From: Amanda Scholes on behalf of Planning.Responses
Sent: 10 April 2018 10:16
To: Planning Scanning
Subject: FW: LU/426/17/DOC - Porposed acoustic barrier - Fitzalan Relief Road - WSCC
Highways response dated 14th March 2018

From: Tim Townsend [mailto:tim.townsend@westsussex.gov.uk]
Sent: 10 April 2018 10:07
To: Michael Eastham
Cc: SU Local Development; Planning.Responses
Subject: RE: LU/426/17/DOC - Porposed acoustic barrier - Fitzalan Relief Road - WSCC Highways response dated 14th March 2018

From: Tim Townsend [<mailto:tim.townsend@westsussex.gov.uk>]
Sent: 14 March 2018 09:59
To: Planning.Responses
Cc: Michael Eastham; Gary Markwell
Subject: LU/426/17/DOC - Porposed acoustic barrier - Fitzalan Relief Road - WSCC Highways response dated 14th March 2018

Fitzalan Link
S278 Works: Landscape
Proposals 1 of 2

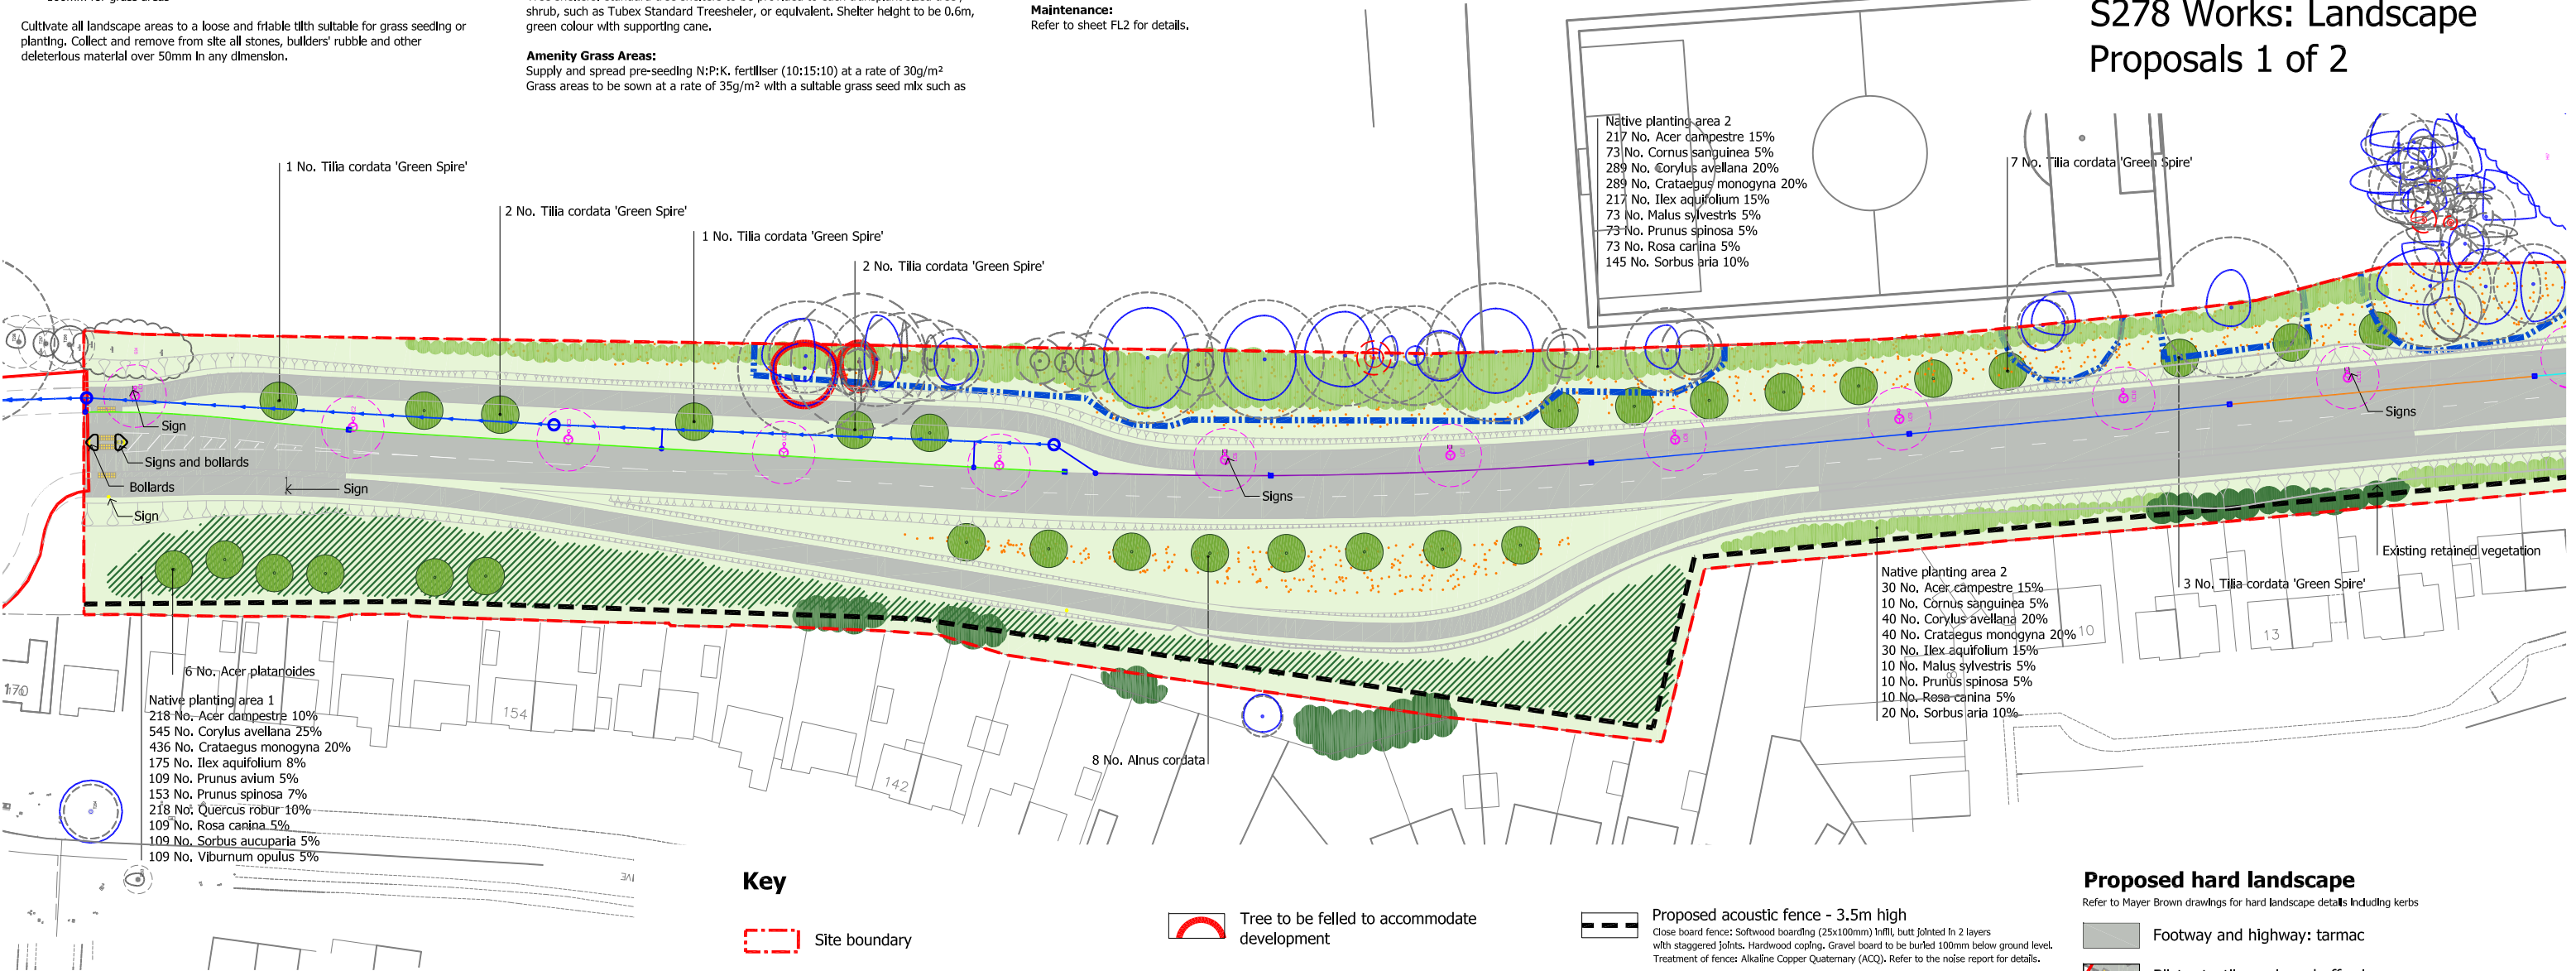
12. Land to rear of 22 to 30 Highdown Drive (brown area): It is not clear from the drawing whether some of this area is included within the site boundary. Access will be required for maintenance of the land. *Applicant to respond further. Reply from applicant is that this is to be checked. Further reply awaited.*
14. The detailed design for the academy roundabout shows the central island as being hard paved with no planting. *Please provide comments from the highway designer setting out whether it is appropriate to accommodate planting here. Applicant has said that it is for the engineer to respond. Further reply awaited.*

12. Land to rear of 22 to 30 Highdown Drive (brown area): It is not clear from the drawing whether some of this area is included within the site boundary. Access will be required for maintenance of the land. *Applicant to respond further. Reply from applicant is that this is to be checked. Further reply awaited.*
13. The detailed design for the academy roundabout shows the central island as being hard paved with no planting. *Please provide comments from the highway designer setting out whether it is appropriate to accommodate planting here. Applicant has said that it is for the engineer to respond. Further reply awaited.*

On point **12**, the land to the rear of 22 and 30 is owned by the applicant and could be accessed via a maintenance gate. This is acceptable to Highway Authority – actual location to be checked at detailed design/S38/278 stage.

On point 12, the land to the rear of 22 and 30 is owned by the applicant and could be accessed via a maintenance gate.
